From: Paul Cann
Sent: 11 October 2017 14:32
To: Planning.Responses
Subject: RE: Planning Consultation on BE/106/17/DOC

APPLICATION **BE/106/17/DOC**
NO:

Site Address: 27 North Bersted Street Bersted PO22 9AA

Description of Works: Application for approval of details reserved by condition imposed under BE/45/16/PL relating to conditions 3-schedule & samples of materials & finishes, 4-landscaping scheme, 5-details of screen walls and/or fences, 6- vehicle access construction, 7-Construction Management Plan, 8-surface water drainage, 9-details of foul sewerage disposal, 10-maintenance of SUDs system, 11-access & management of any watercourse, 15-details of waste & recycling enclosures & 18-covered & secure cycle parking spaces.

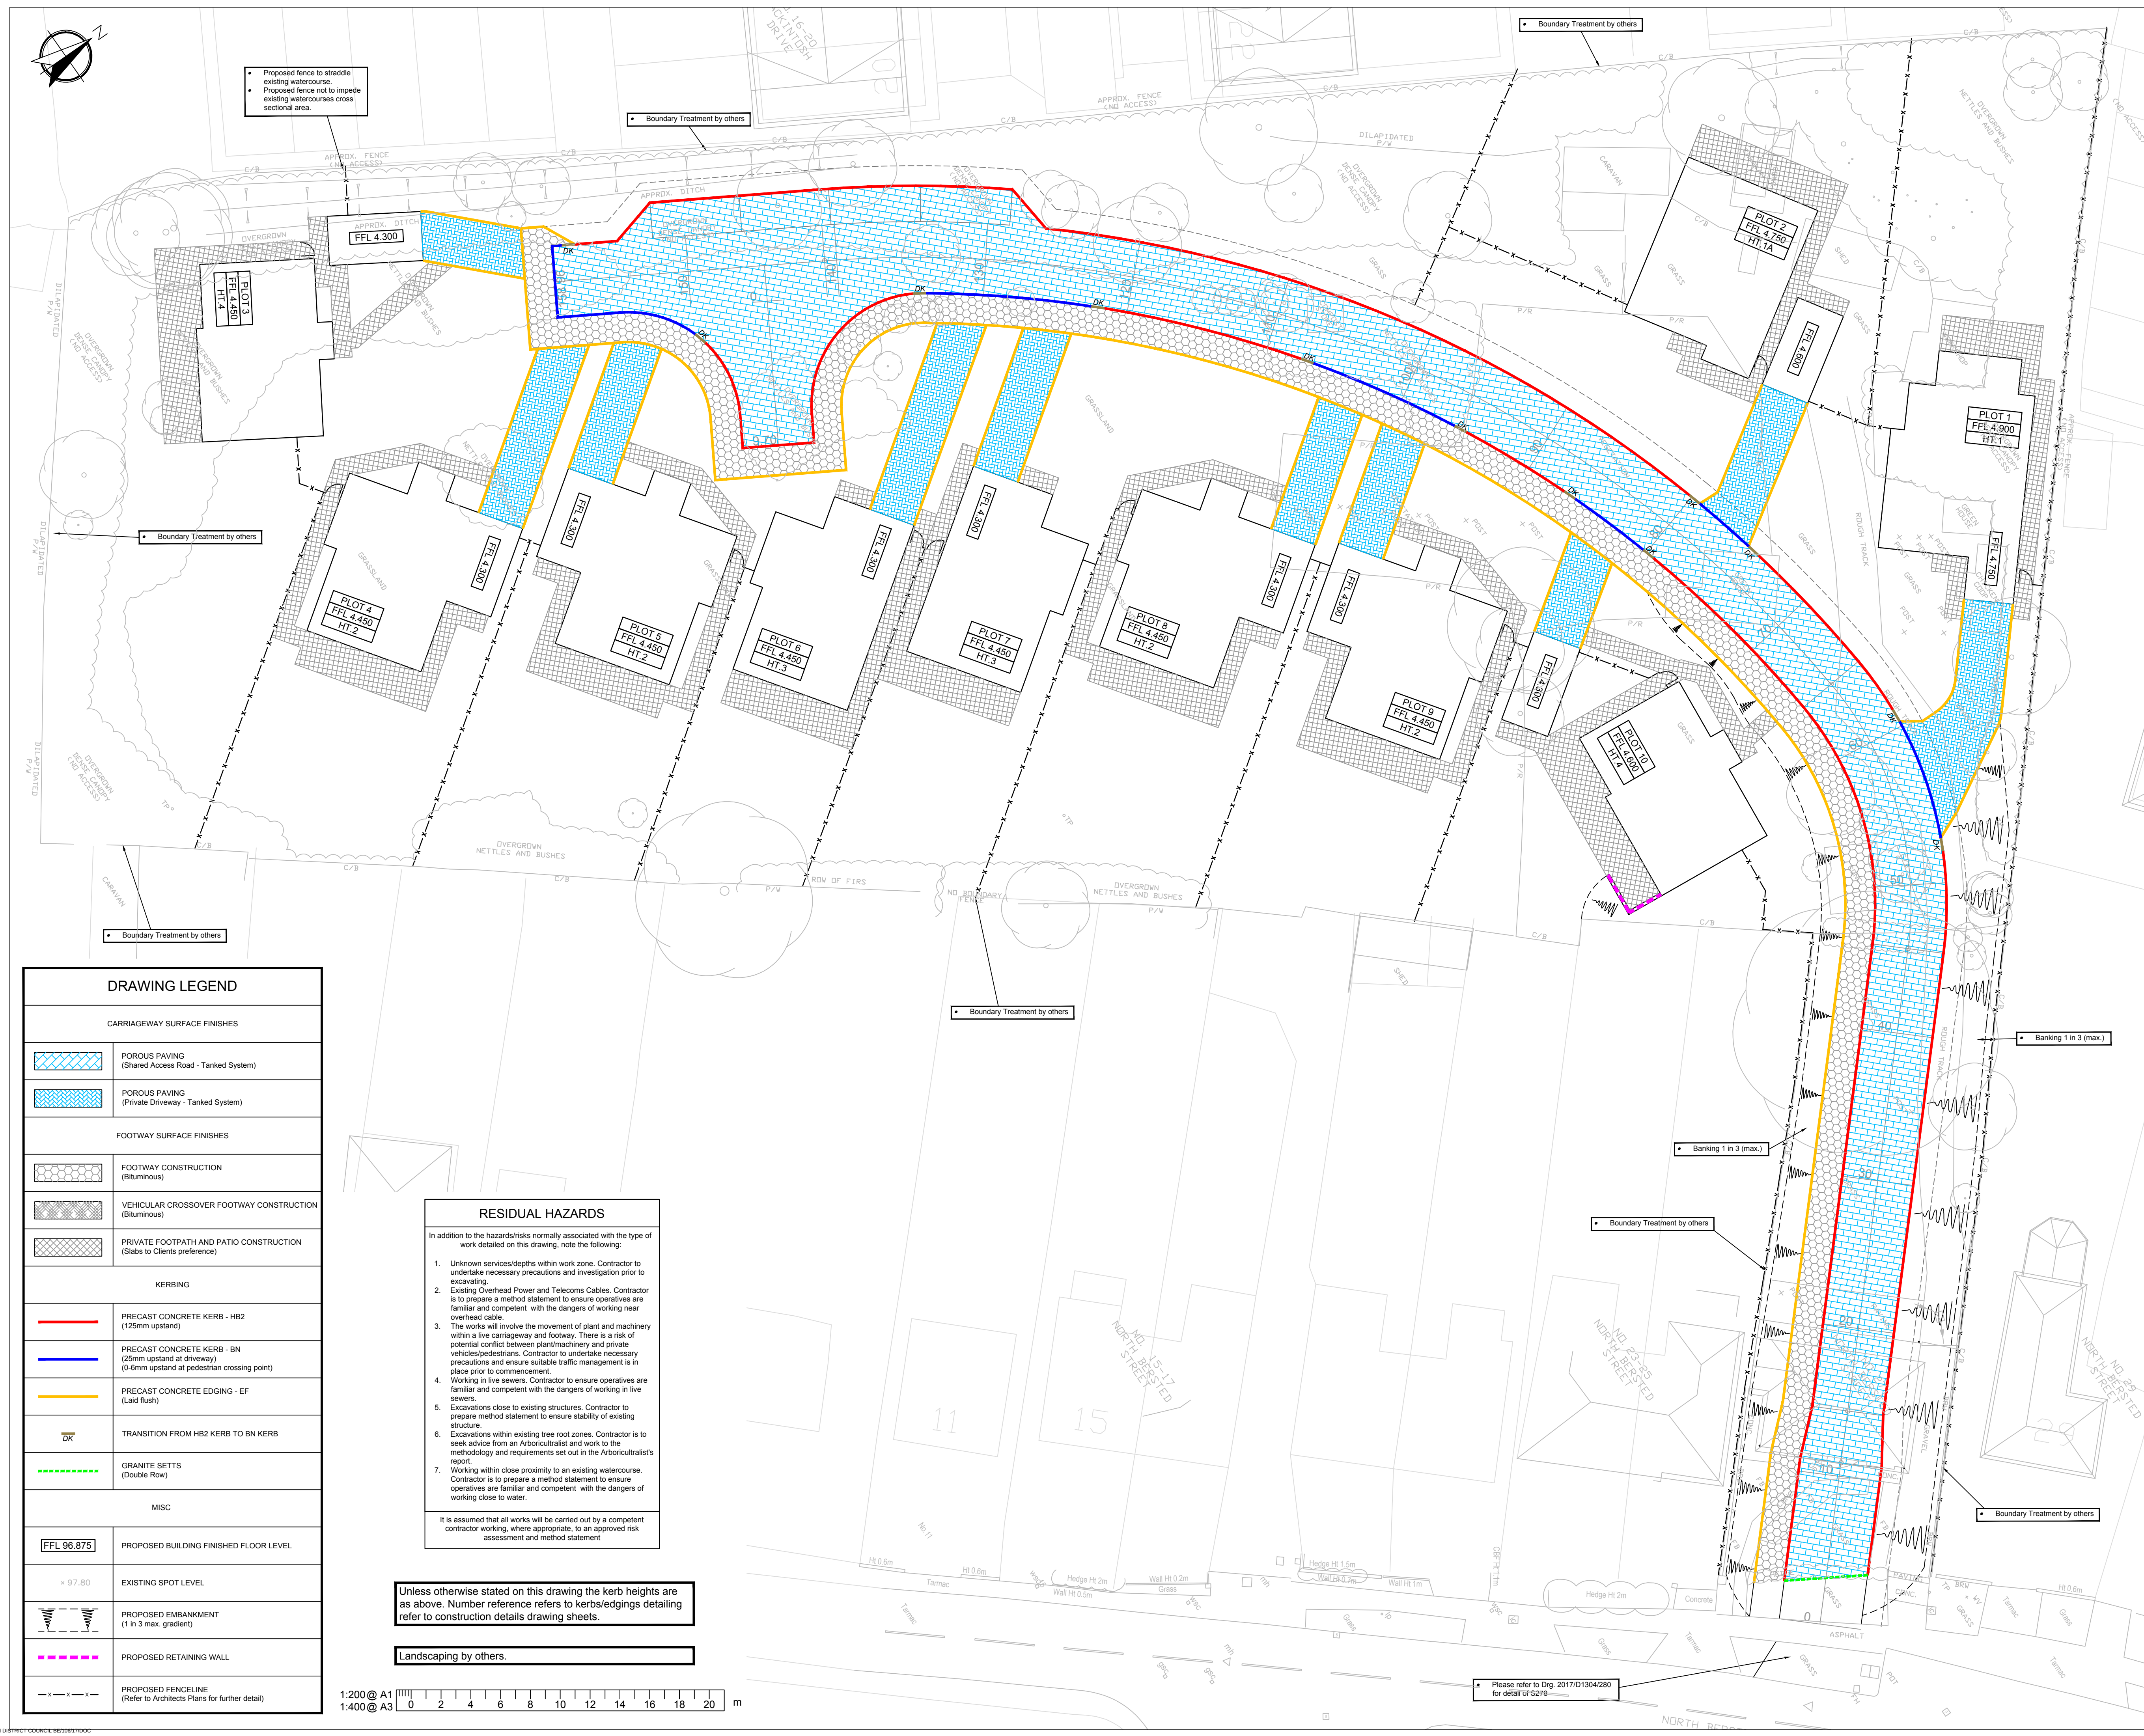
Southern Water have raised an objection to the construction of permeable paving in the vicinity of the foul drainage network. This has a fundamental effect on the proposed surface water drainage scheme and needs to be resolved before further consideration can be given to the scheme. The design will ultimately need to be supported by hydraulic calculations, technical data from the manufacturer of the hydrobrake and written approval from WSCC in respect to the proposed connection to the highway drainage system.

The granular sub base to the permeable paving to be type 3 stone to ensure min. 30% voids. More details are required as to how the permeable pavement discharges to the manhole upstream of the control chamber ie. More formal arrangement required where perforated pipes are intersected. Specify base levels of permeable pavement construction on layout drawing.
